Planning & Urban Development Department

January 22, 2015

We received an application for a Level I- Site Alteration for 245 Taft Avenue. The project description states "Grub stumps, Grade lot". The application also states that the total area of the site is 43,200 square feet and the total disturbed area will be 43,200 square feet for a garden. Included with the application is a plan by Livingston-Hughes that is titled Retracement of Lots 301-314 and 323-336 "Portland Gardens".

DRAWING NO. C-10

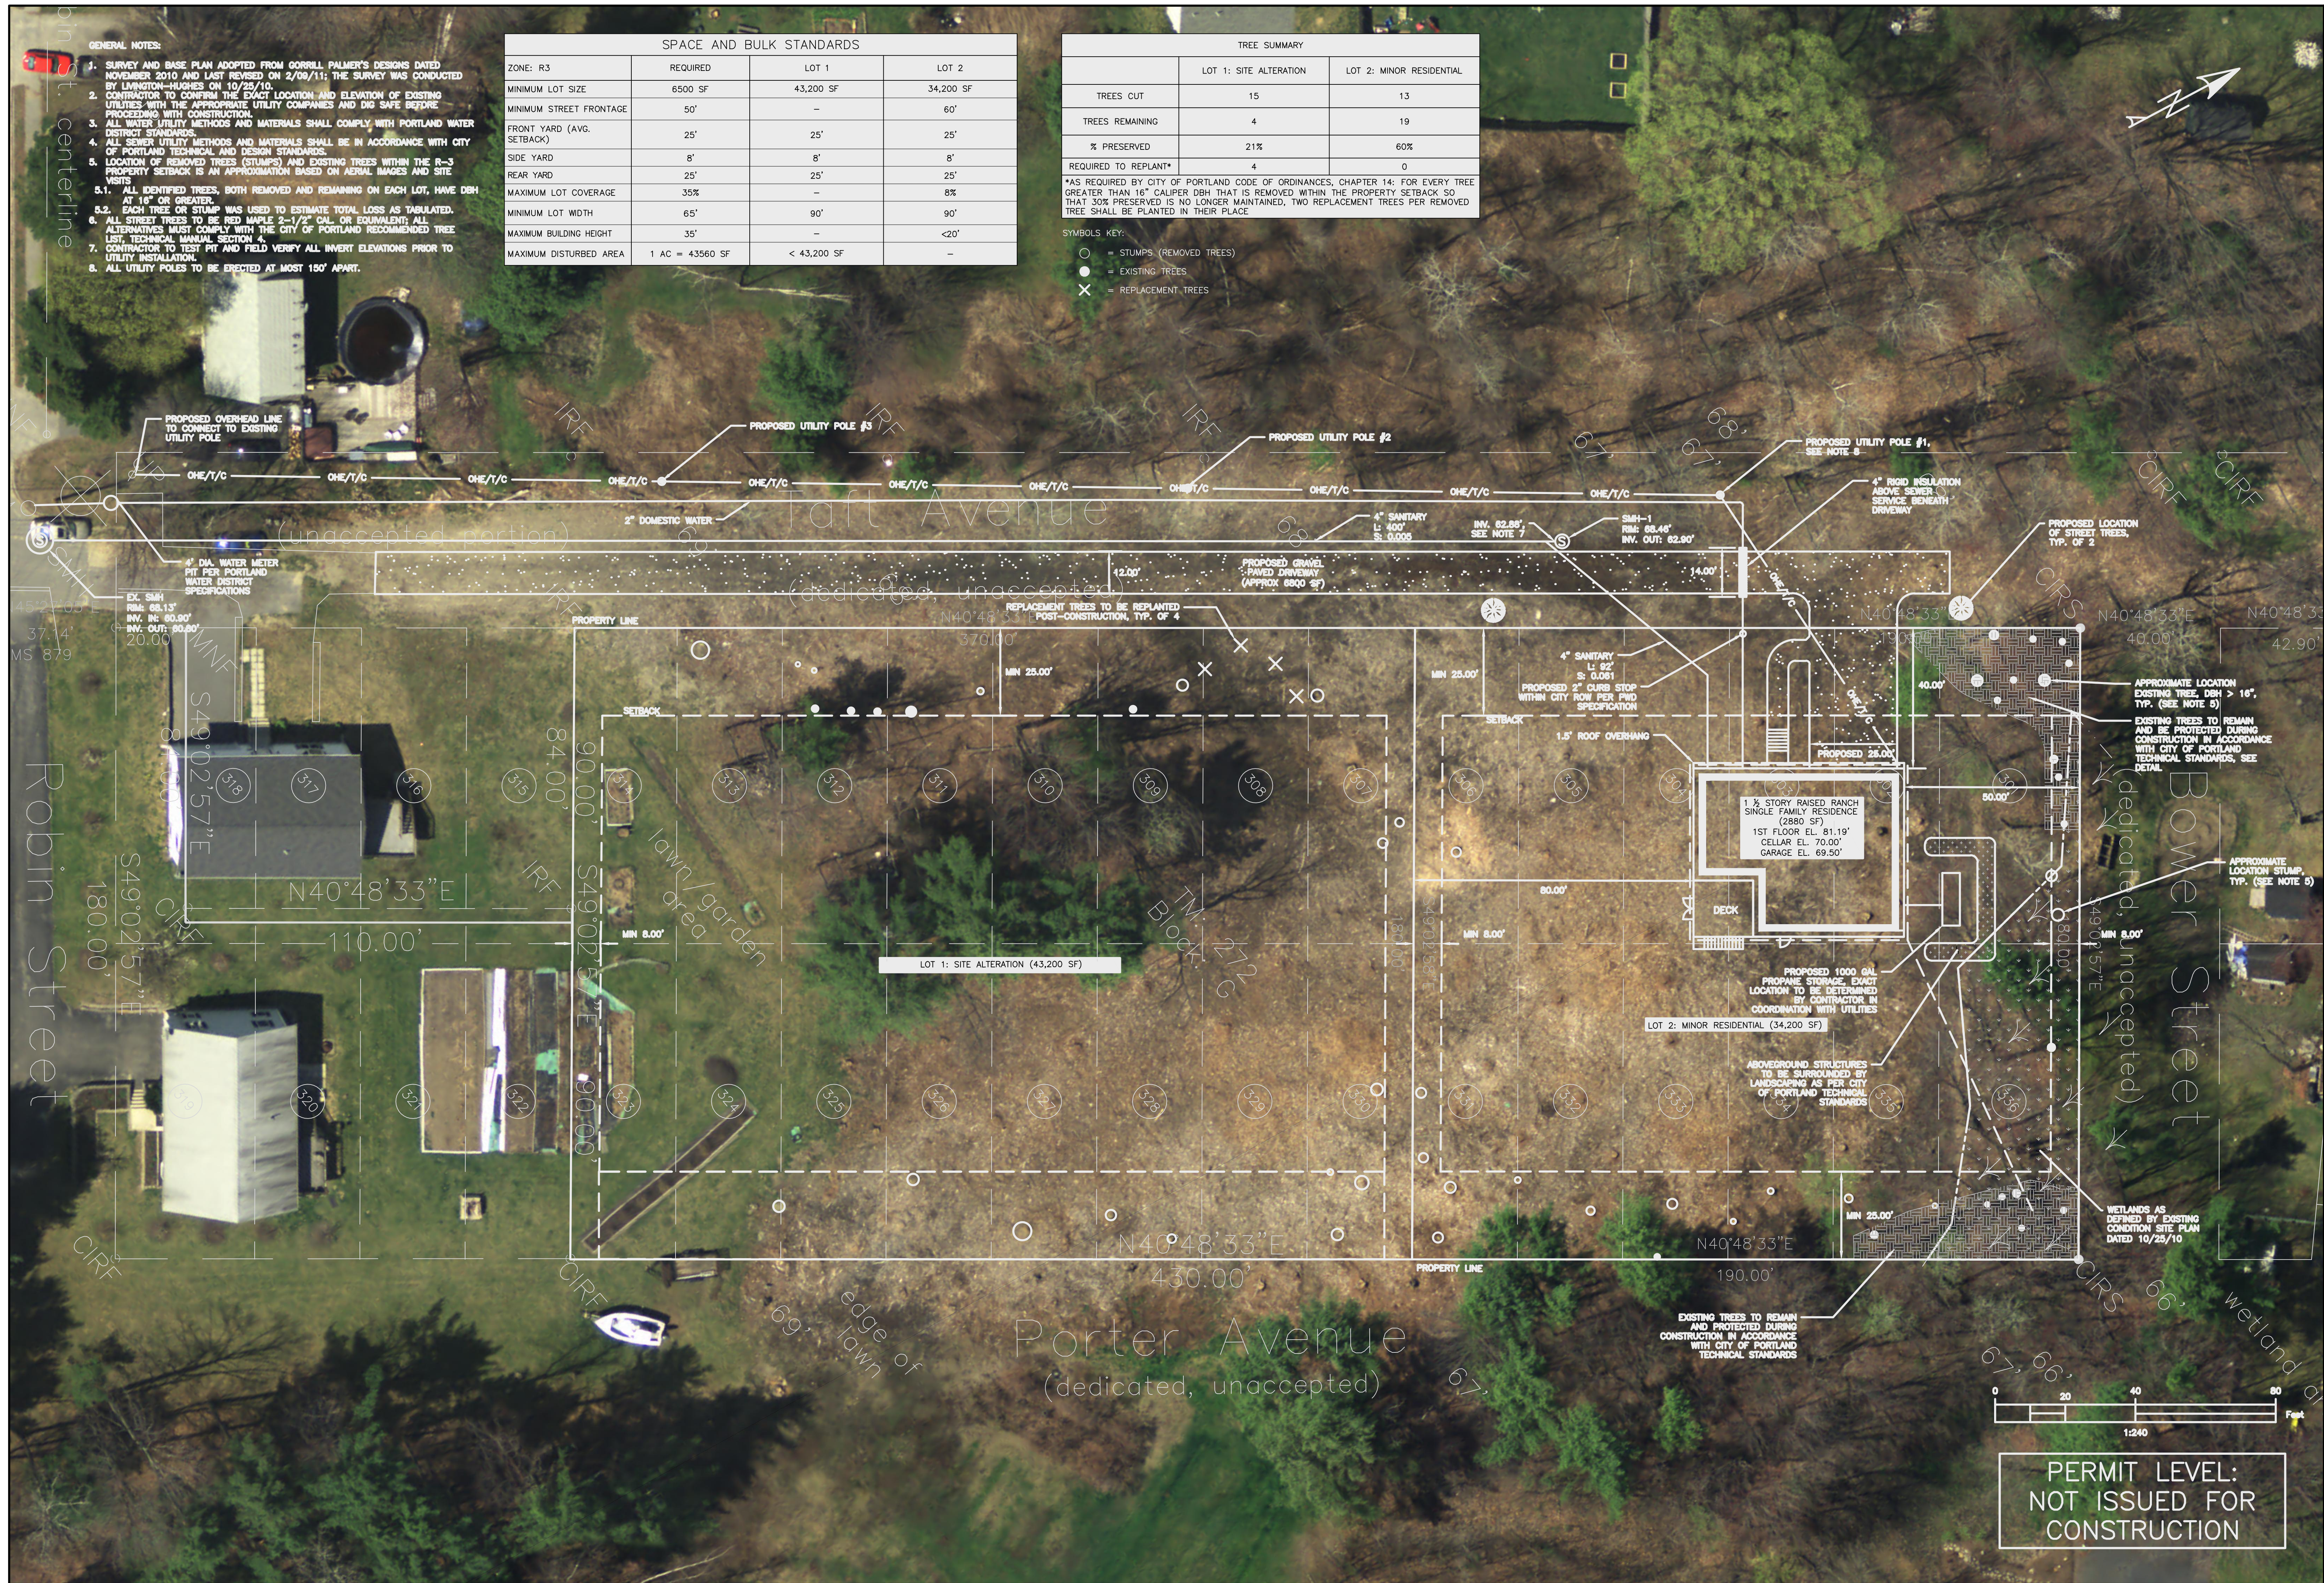
The submitted boundary plan shows topography and it is the same plan submitted with your previous application as the boundary survey and existing conditions. The existing contours extend beyond the area shown as the site for the garden. The application is incomplete without a site plan of the proposed site changes. Please submit a site plan, meeting the requirements of the ordinance and outlined in the attached checklist, which accurately depicts the area to be grubbed and disturbed, the amount of fill to be brought to the site, and the final grades and topography for the garden. Also, please show any paths or travel ways along with the proposed surface materials that you may be considering for access to the garden. If you are intending on grading beyond the lots marked on the plan, then that needs to be shown on the plan and it may trigger a Level II review.

1. Please submit a Level I site plan that includes the following information:
 - Please show any existing and proposed paved areas.
 - Please show any utilities you may be extending.

- Please identify and show proposed impacts and protection measures for alterations of any watercourse or wetlands.
 - Please add to the site plan, the proposed grading contours and the amount of any fill that may be proposed for the garden. The grading plan should be clear that neighboring properties are not negatively impacted by stormwater surface drainage, ie berming and swaling so that stormwater is directed to the front of the site towards the street, etc.

- Please add to the site plan, the required erosion control measures ie. silt fence or erosion control mix (erosion control plan) in the appropriate areas.
